RESPONSE TO SUBMISSIONS

Adaptive reuse of heritage listed dwelling to facilitate pre-school and primary school use including alterations and additions, on-site car parking, tree removal, landscaping and fencing

1 Rosemead Road
HORNSBY

REF: M200276
DATE: 11 November 2020

5 INDICATIVE DETAIL NEW ROSEMEAD ROAD ENTRY GATES
1 : 20

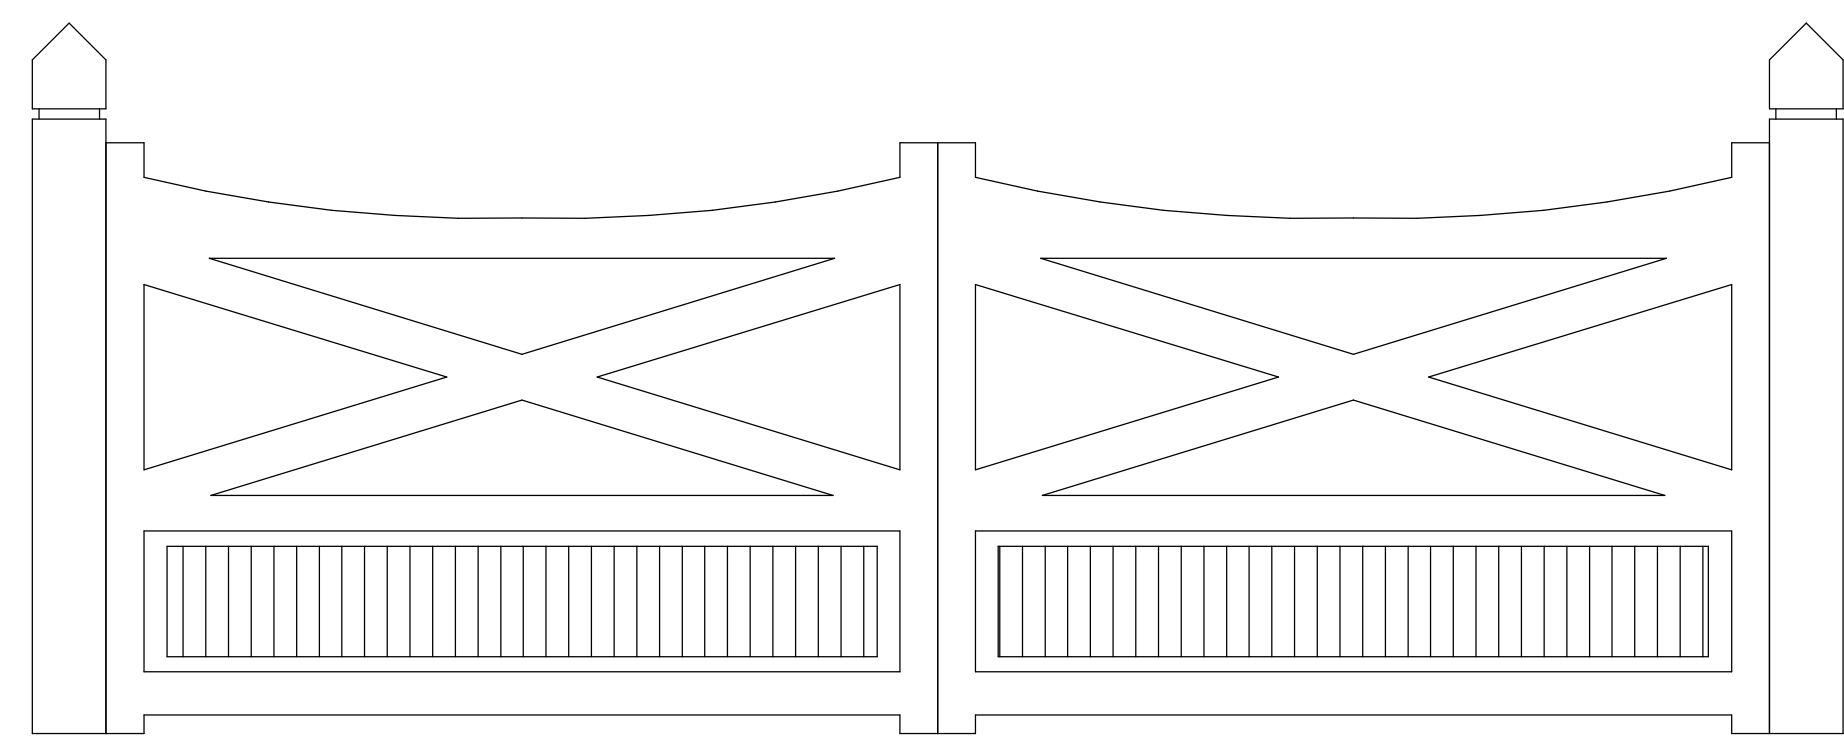
<p>d) Existing Mount Errington gates and posts</p>	<ul style="list-style-type: none"> The original gates and posts should be retained in situ 	<p>The original gates and posts cannot be retained due to the existing condition of the fabric, including borer damage and rotting timber due to water damage.</p>
		<p>Alternative options have been explored which would not require a widening of the posts,</p>

<ul style="list-style-type: none"> Alternative solution to meet heritage requirements. 	<p>however on balance it was deemed not to be the best solution for the site. The options analysis is fully outlined in Section 3 of this report.</p>
<p>e) Existing timber fence replacement</p> <ul style="list-style-type: none"> Alternative design, materials and finish to meet heritage and regulatory requirements. 	<p>The proposal has been revised to provide for installation of gates based upon the design, scale and form of the original gates (widened to allow for use of the driveway for vehicle access). This is supported by Heritage 21 (heritage consultant) as per their Addendum Heritage Report (Attachment 3).</p>
<p>f) New powder coated metal fencing and egress/access gates</p> <ul style="list-style-type: none"> Alternative design, materials and finish to meet heritage and regulatory requirements. 	<p>The front fence to Rosemead Road has been amended from metal fencing to a timber picket fence.</p>

1 STAFF ONLY HANDRAIL DETAILS
1 : 10

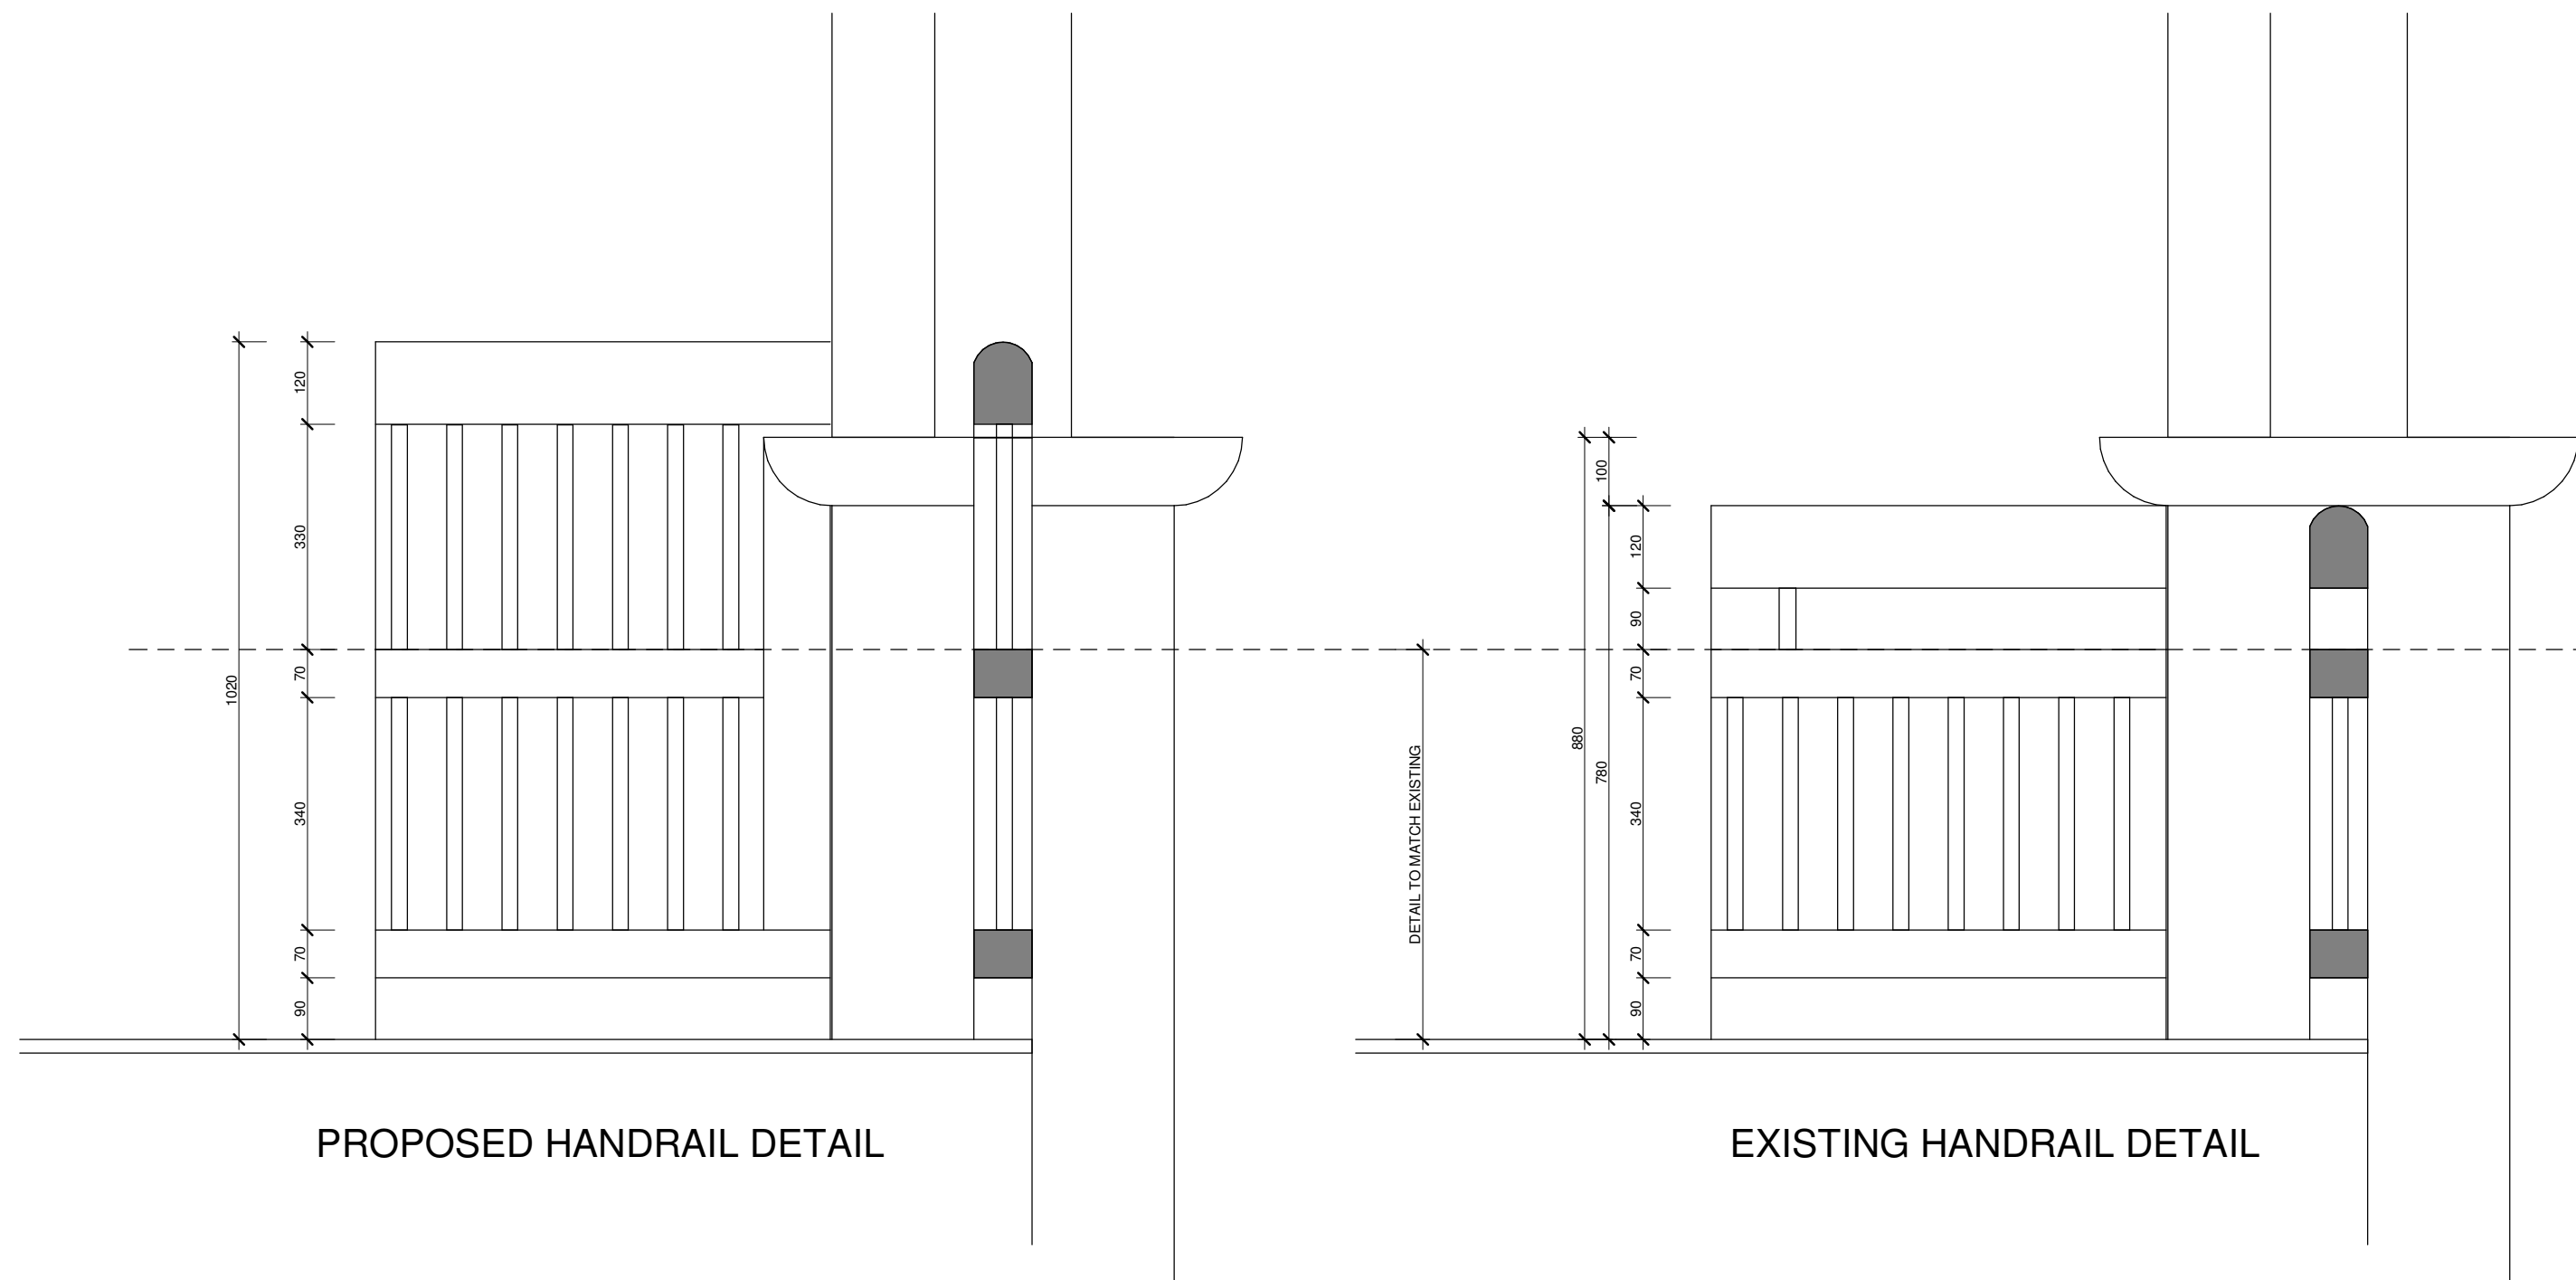
<p>j) New drop off and pick up footpath</p> <ul style="list-style-type: none"> Alternative material and finish to meet heritage and regulatory requirements. 	<p>Concrete has been changed to decomposed granite, with matched brick edging.</p>
<p>k) Raised balustrade on first floor balcony</p> <ul style="list-style-type: none"> The original balustrade should be retained. An alternative solution and justification to meet heritage and regulatory requirements 	<p>Alternatives have been considered to retain the existing balustrade, such as introducing a glass ‘inner’, however the proposed installation of a new balustrade is deemed the most appropriate heritage response. An Addendum Heritage Report (Attachment 3) advises that the proposed balustrade would maintain the existing form and proportions of the existing and would generate a minimal impact upon the views to the existing heritage item. Alternative options, would generate a negative heritage impact.</p> <p>Not applicable - alternative design not proposed.</p>
